April 30, 2008

RE: Schmaus #4 Preliminary Plat (P-07-55)

Holly Duncan
Environmental Health Specialist

**SCHMAUS No. 4 PLAT**  
PTN. SW1/4 OF SECTION 21, T.20N., R.14E., W.M.  
KITITAS COUNTY, STATE OF WASHINGTON

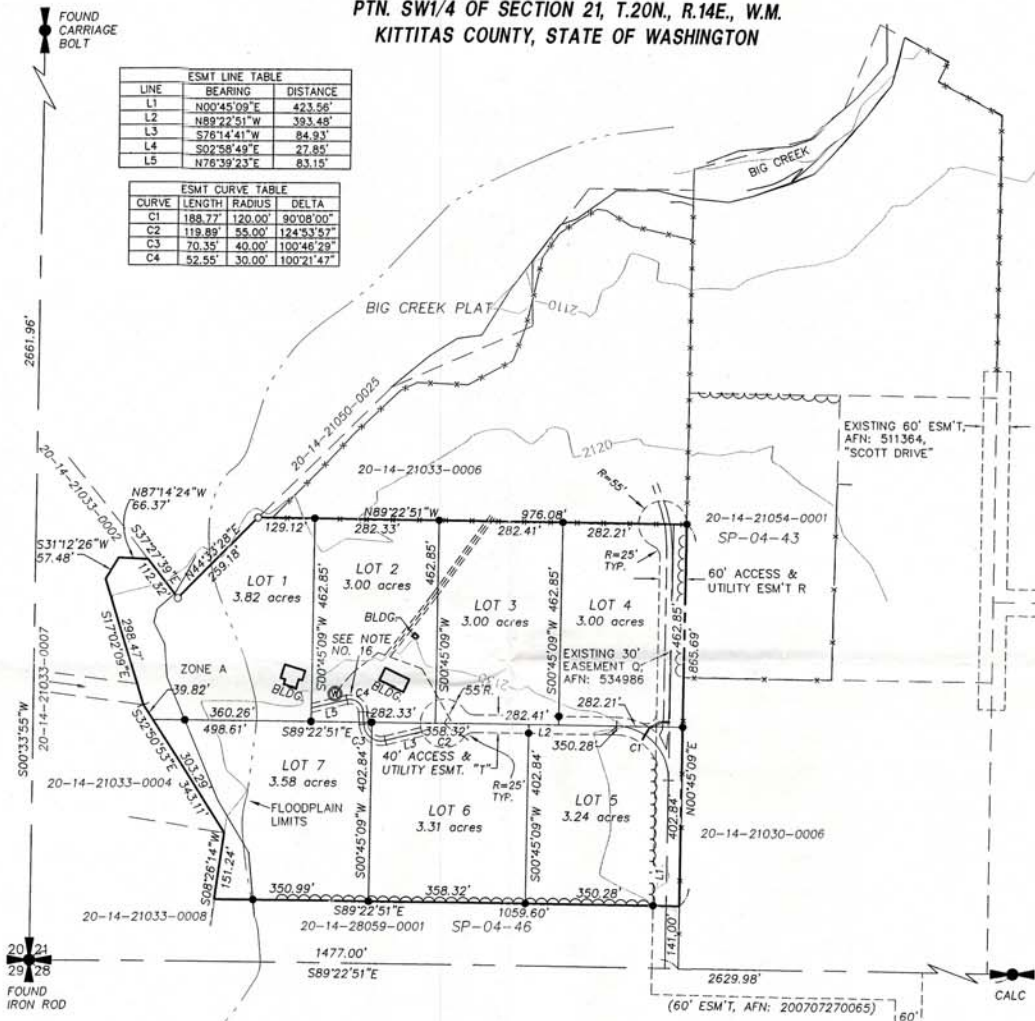
Thank you for the opportunity to comment on the above referenced project. I recommend that the existing well on lot 2 be used as a Group B water system to serve the seven proposed lots. A well site inspection must be performed to approve the site where the well is. The group B workbook and all associated paperwork must be turned in and the system design approved prior to final plat approval.

The file indicates soil log information is needed on each lot.
